## POST EPC MEMORANDUM

RE: PR-2022-007851, SI-2022-02075-Buddhist Temple, Site Plan – EPC Major Amendment

**Project # PR-2022-007851**

SI-2022-02075 - Site Plan- Major Amendment

ISSUE/REVISION
PROJECT NUMBER:
20_1611.03
CAD DWG FILE:
DWL-NM_APS_OSUNA
DRAWN BY:
S.S.
CHECKED BY:
W. EASTMAN
SHEET TITLE:
TRASH ENCLOSURE
PLAN AND DETAILS
A1.3
XX OF XX SHEET

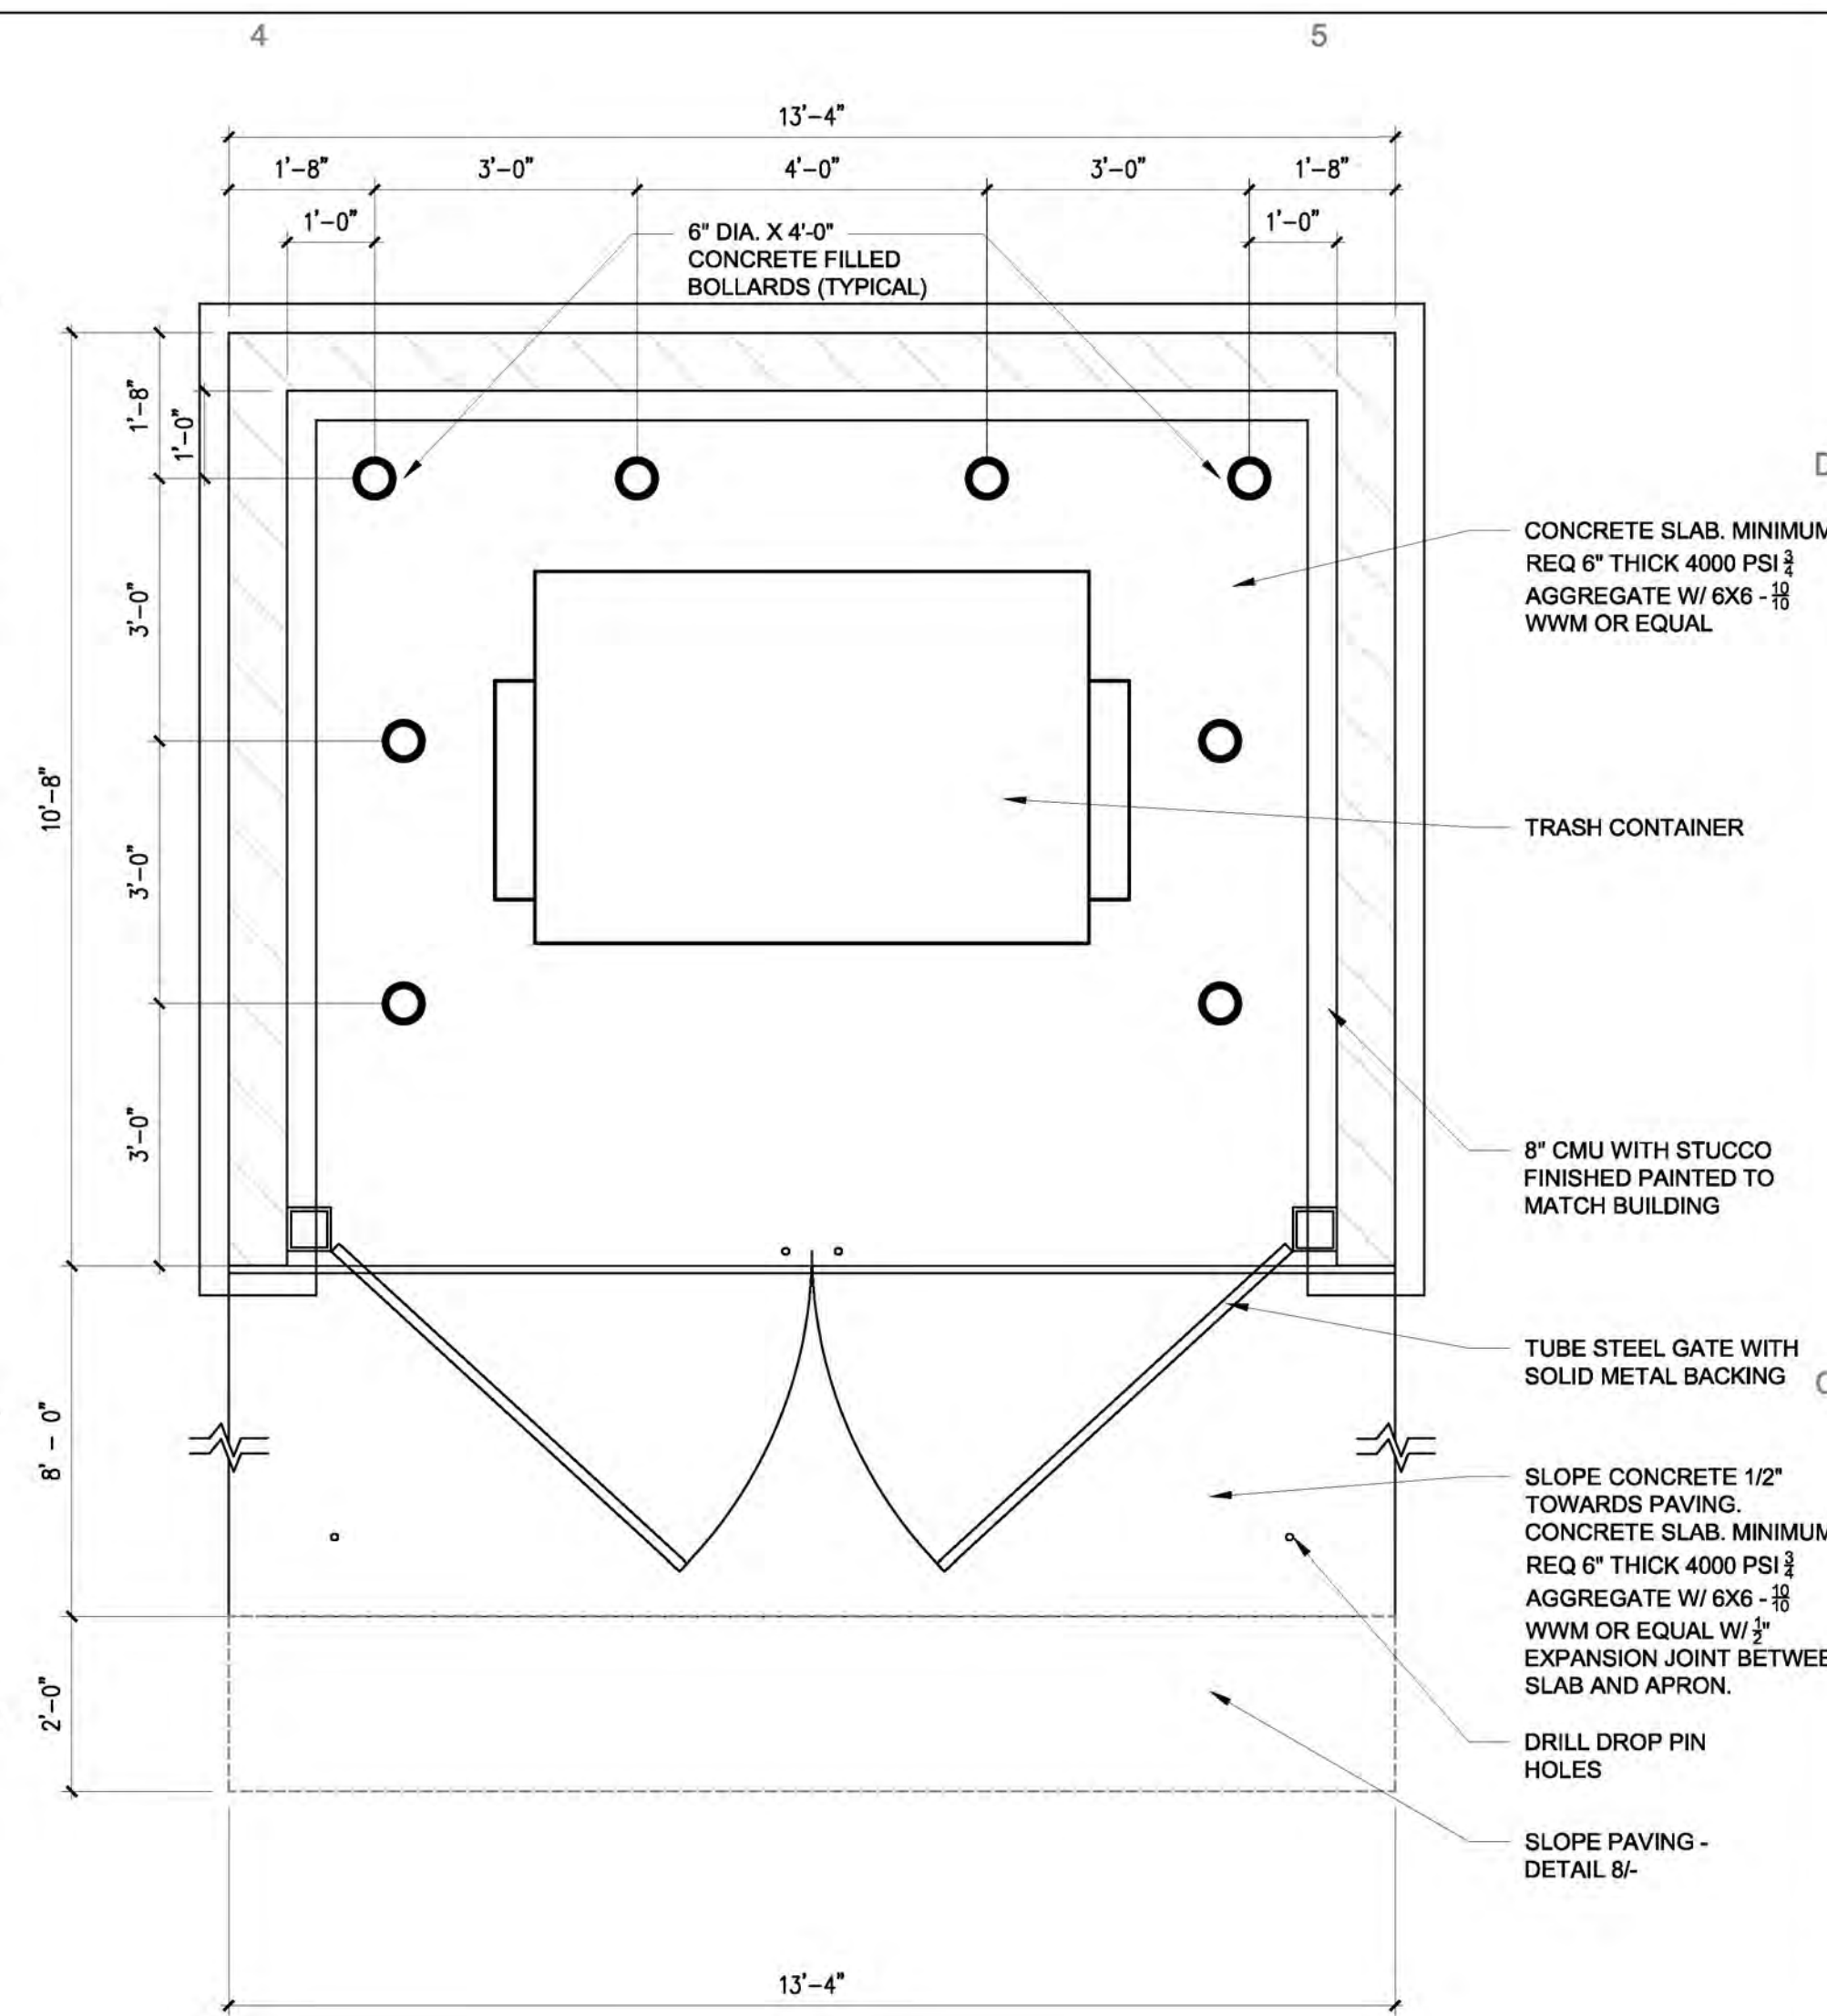
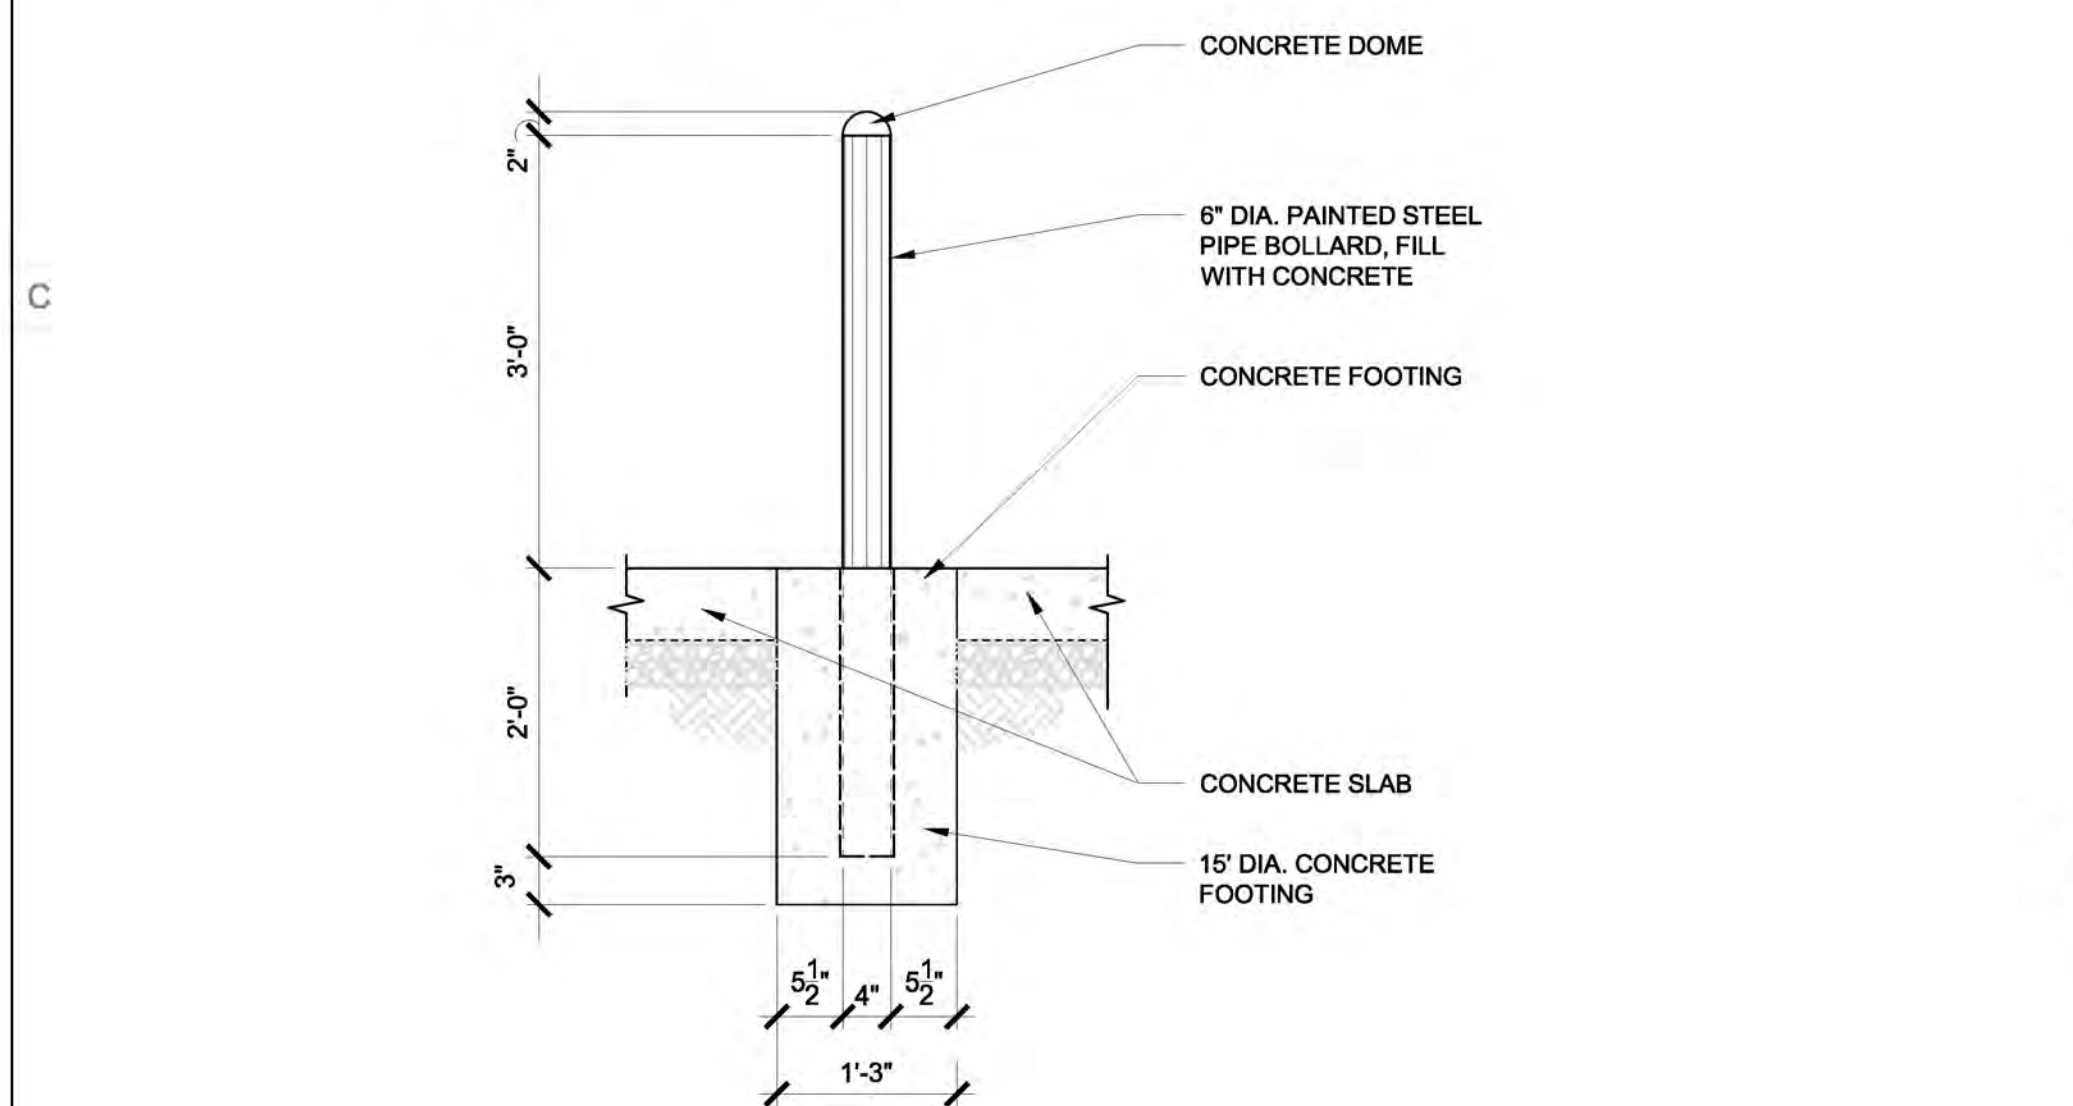
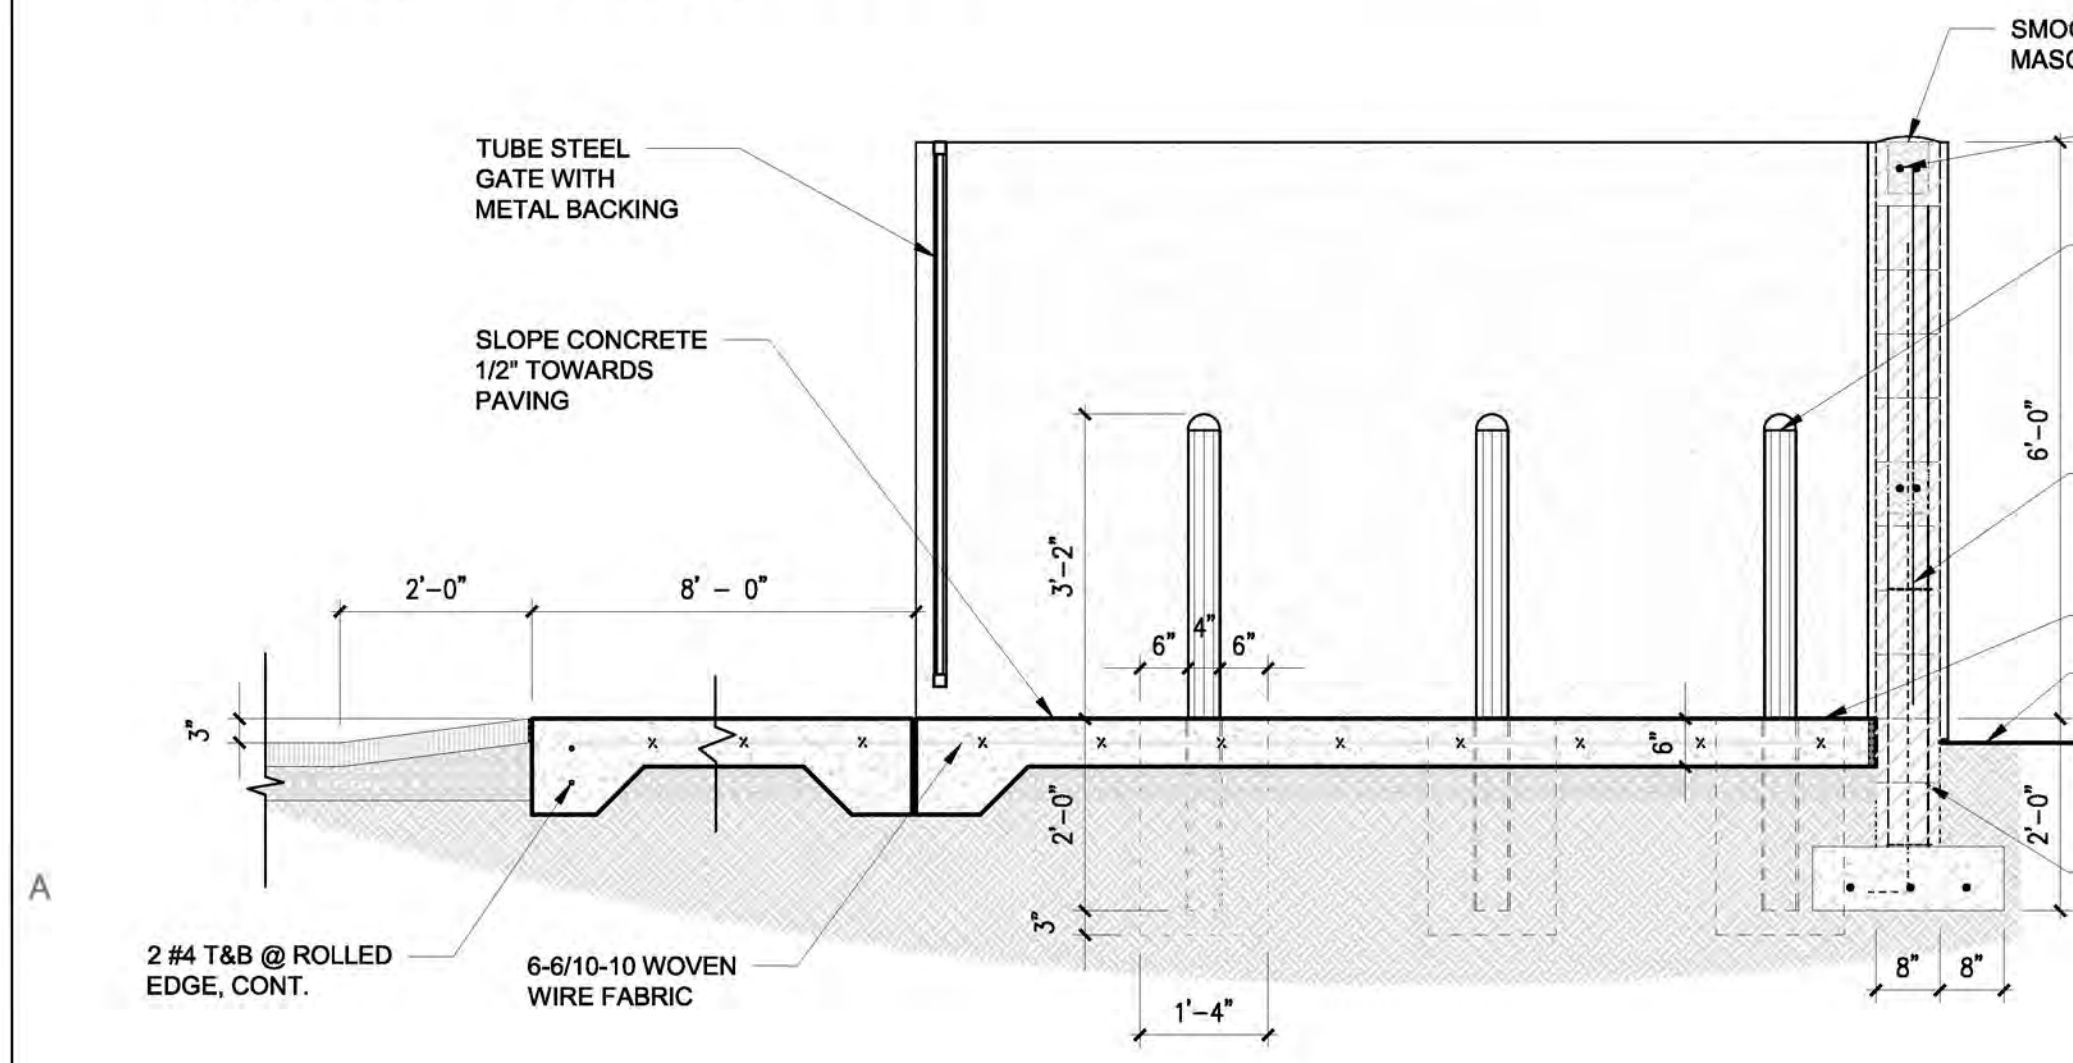
- B. The trash enclosure will have to meet the City of Albuquerque's minimum requirements.

The trash enclosure design on sheet A1.3 Plan & Details reflect the SWMD dimensions and construction materials requirements of the "enclosure specifications" document. This enclosure does not require an exterior sanitary sewer drain, this facility is not a "Restaurant, Food Services or Food Distributors" function.
